Application no: **3/2019/0771**

Address: **40a Knowsley Road, Wilpshire Road, Blackburn, BB1 9PX**

Proposal: **Construction of a two car carport on the southern boundary of the property**

PLAN VIEW

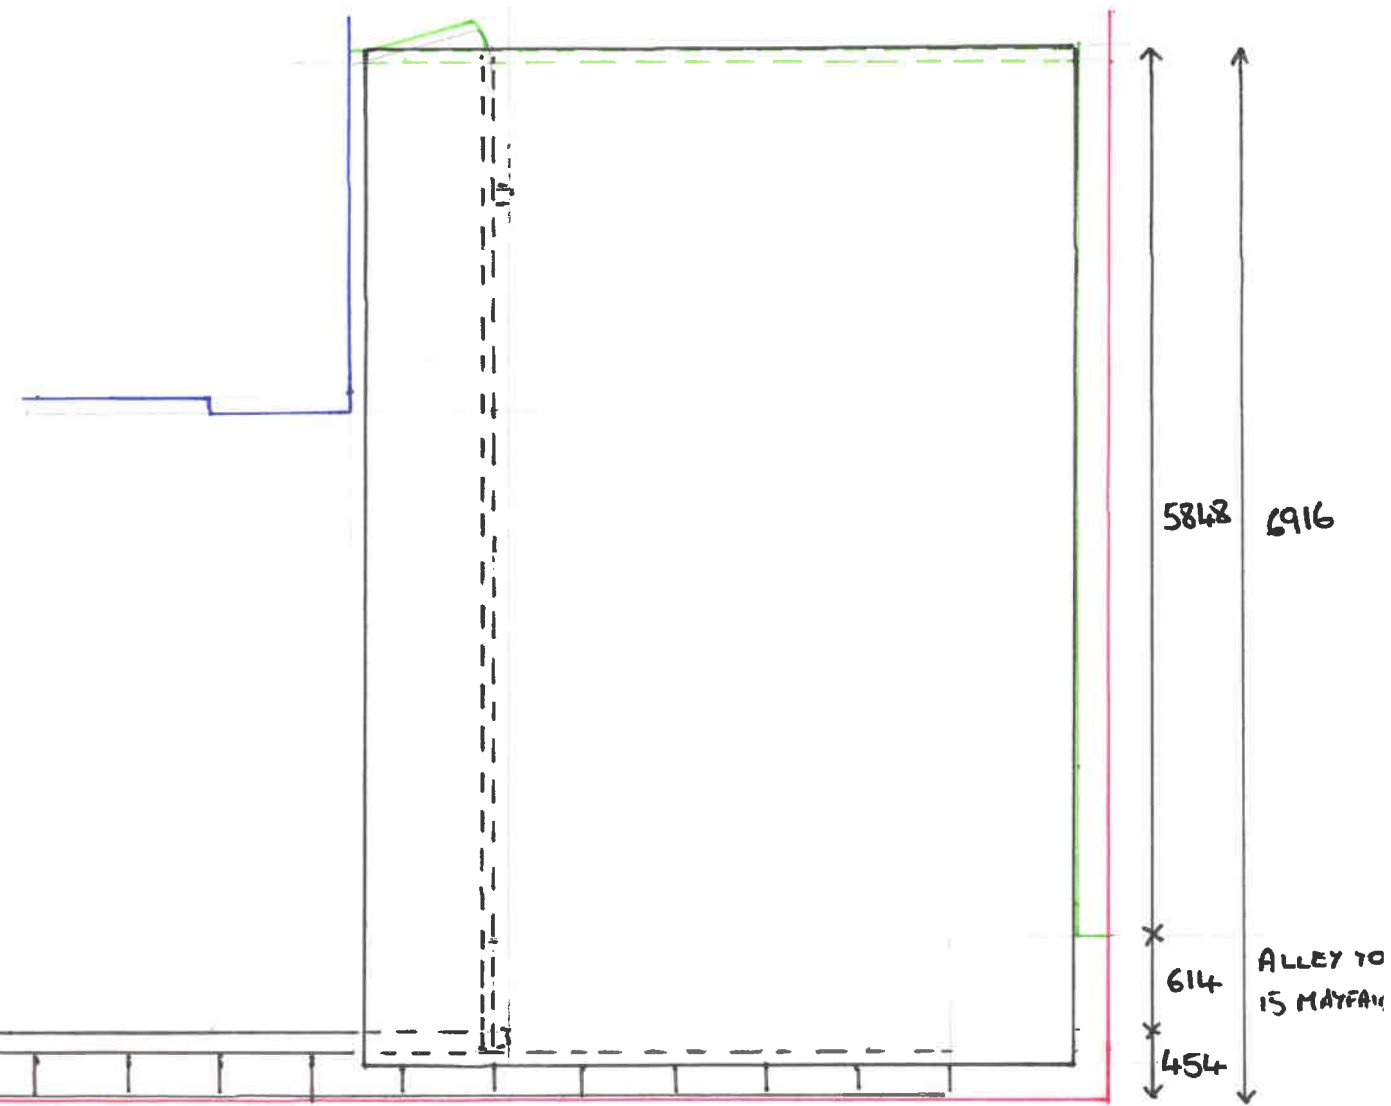
The recently submitted drawings are deemed insufficient and the local highway authority would require a detailed scaled drawing of the proposed parking arrangements. I have also explained that the local highway authority has raised no objection to the principle of the proposal although we do need to understand that the proposal will not affect the local highway network.

The access lane from Knowsley Road to the application site is a privately shared access lane which also serves the rear of neighbouring properties 22-40 Knowsley Road, a number of neighbouring residential garages and a public right of way. Therefore the applicant needs to demonstrate that the access to the aforementioned will not be obstructed as a result of the proposal.

The number of parking spaces is also to increase as a result of the proposal from 4 to 5 parking spaces. Access to the rear of Knowsley Road is tight with poor visibility at the access point and the existing/proposed driveway has not got the availability to accommodate the proposed amount of parking without infringing the access lane.

The local highway authority therefore requires a dedicated parking layout which would demonstrate the proposed parking arrangements at the application site.

properties and also the public via the public right of way, namely 3-46-FP 21 the applicant will need to demonstrate how the associated parking arrangements will not obstruct the shared access lane to which shall remain free from obstruction at all times.
